Response to Planning application from Hertfordshire County Council (T and CP GDP Order 2015)

District ref: 6/2022/0929/ADV
HCC ref: WH/11933/2022
HCC received: 20 April 2022
Area manager: Matthew Armstrong
Case officer: Steven Knight

35-37 HOWARDSGATE WELWYN GARDEN CITY AL8 6AP

Installation of 1 x illuminated fascia sign, 1 x unilluminated fascia sign, 1x projecting sign and 1x internally illuminated menu board and 1x Chalkboard

DWG TITLE
PROPOSED SHOP FRONT PLAN AND ELEVATION

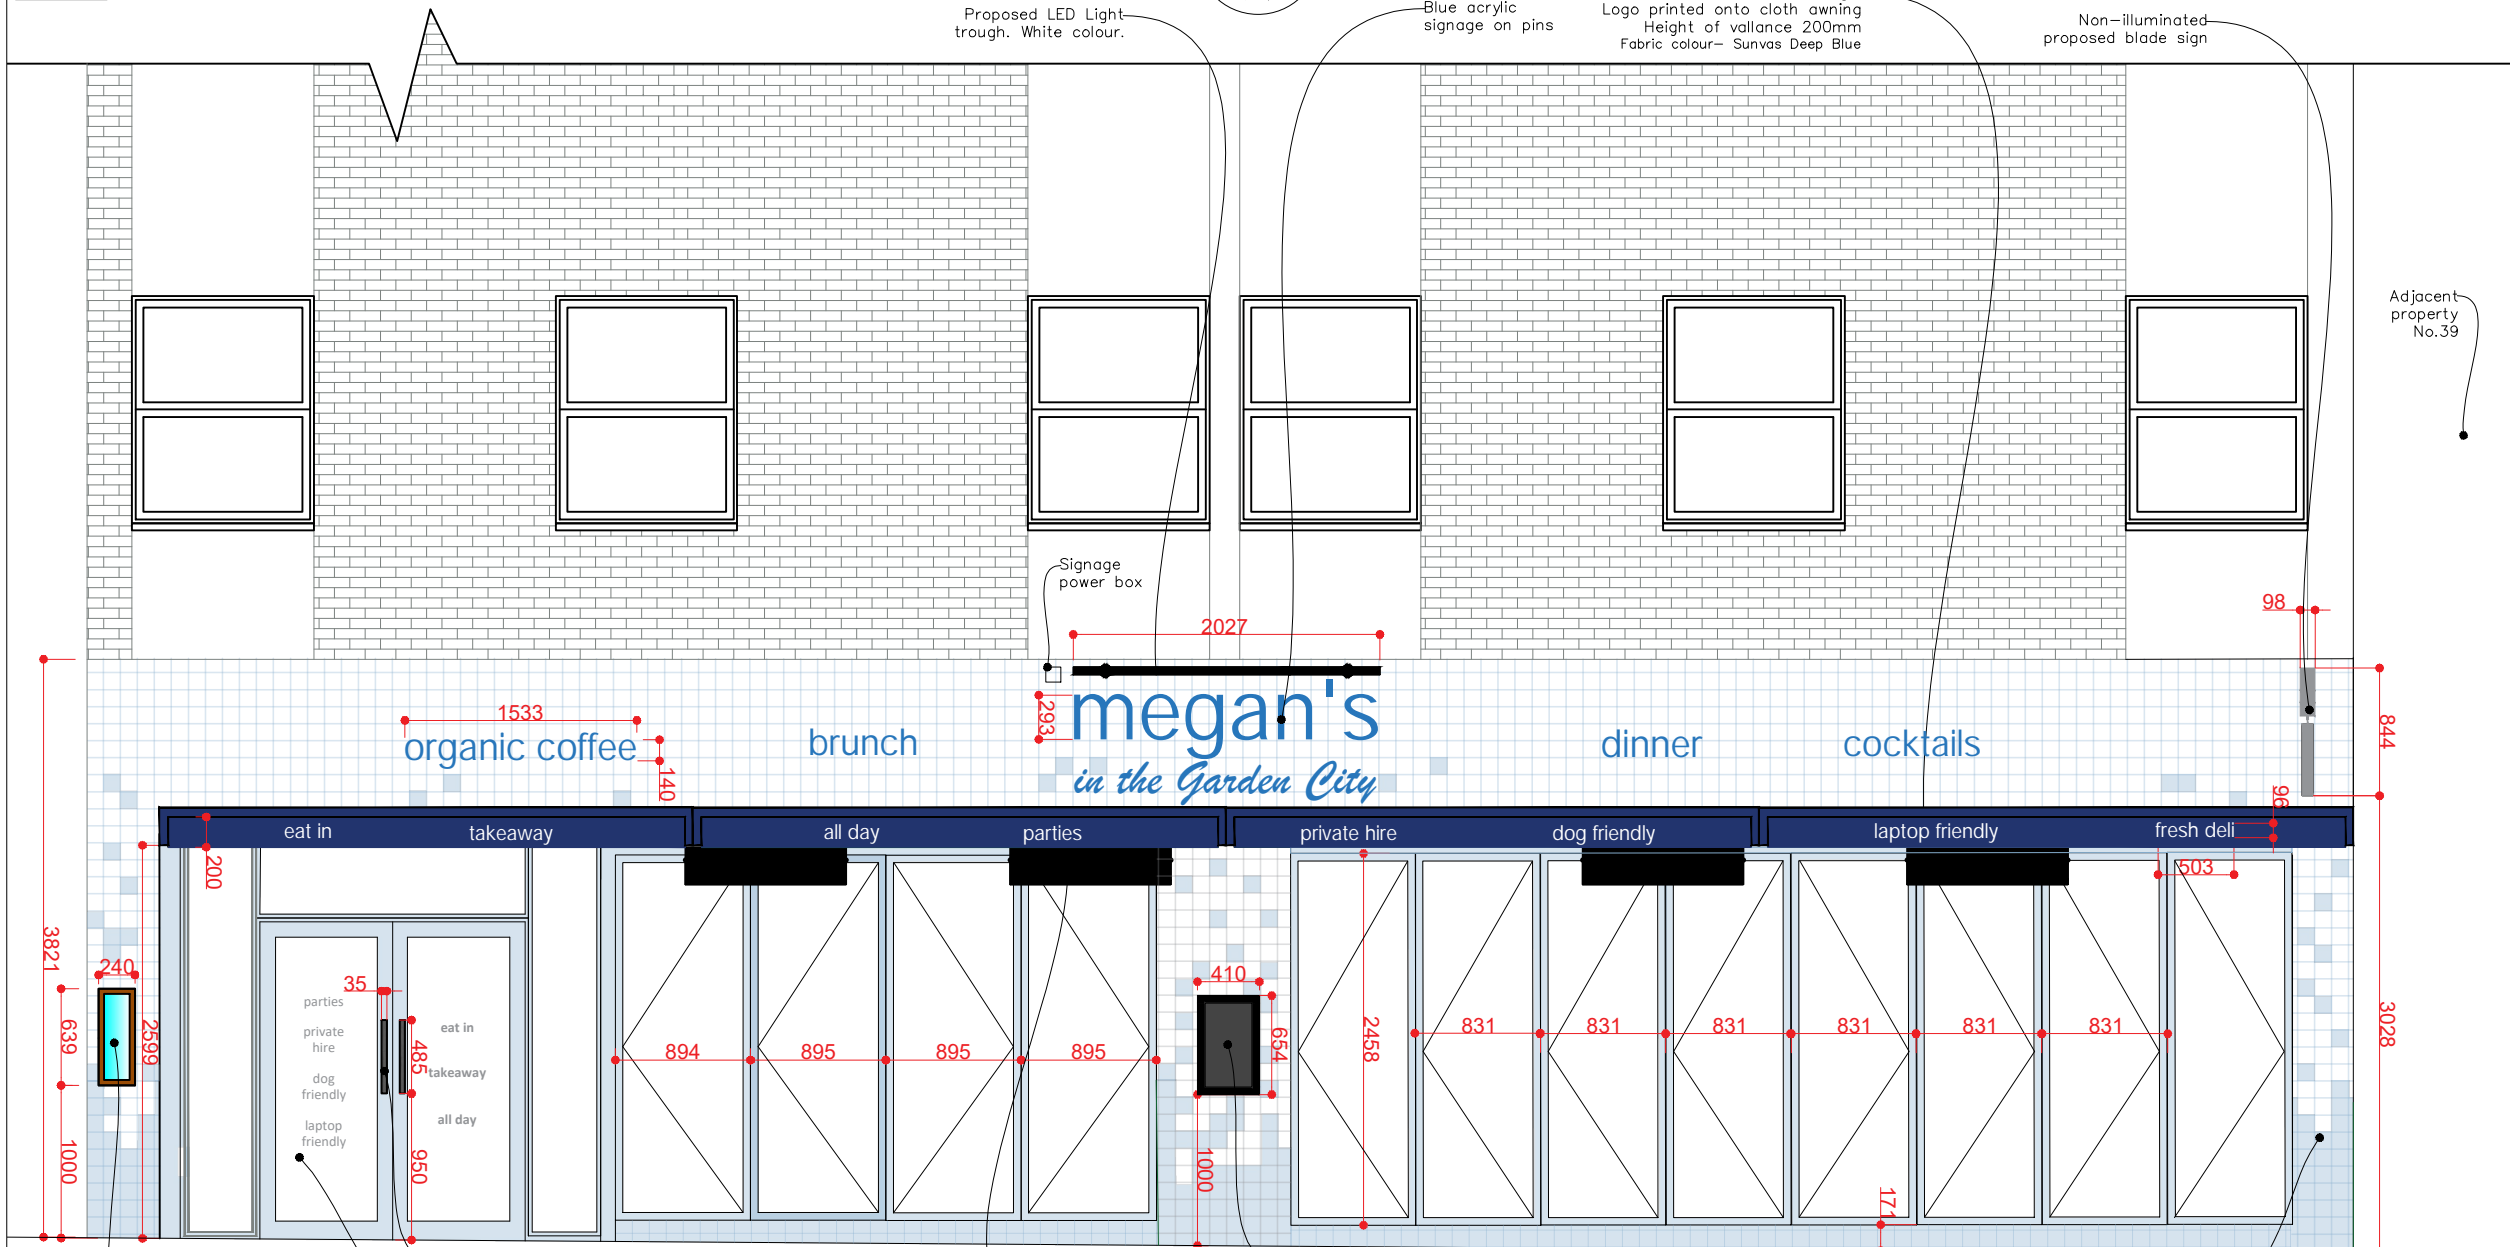
Although the property is currently vacant, the proposed fascia and projecting signs will be similar to those used by the previous occupant. The proposals don't therefore represent an increase in signage or visual clutter. This is an urban, street lit area with multiple other similar signs so the proposal is unlikely to be distracting or confusing to motorists.

The fascia and projecting signs are approximately 3m above the footway which is acceptable. The applicant should be aware that the projecting sign may require a licence to be obtained from the highway authority.

The application form states that the luminance of the fascia sign lighting will be 1600cd/m² which appears to exceed the recommended luminance stated in the ILP's Professional Lighting Guide 05 – The Brightness of Illuminated Advertisements. If approved, a condition is recommended to ensure the lighting is in accordance with this guidance.

Prior to the first use of the development hereby permitted the intensity of illumination shall be provided at a level that is within the limit recommended by the Institution of Lighting Professionals in the publication 'Technical Report No 5: Brightness of Illuminated Advertisements' and 'Guidance Note for the Reduction of Obtrusive Light GN01:20'.
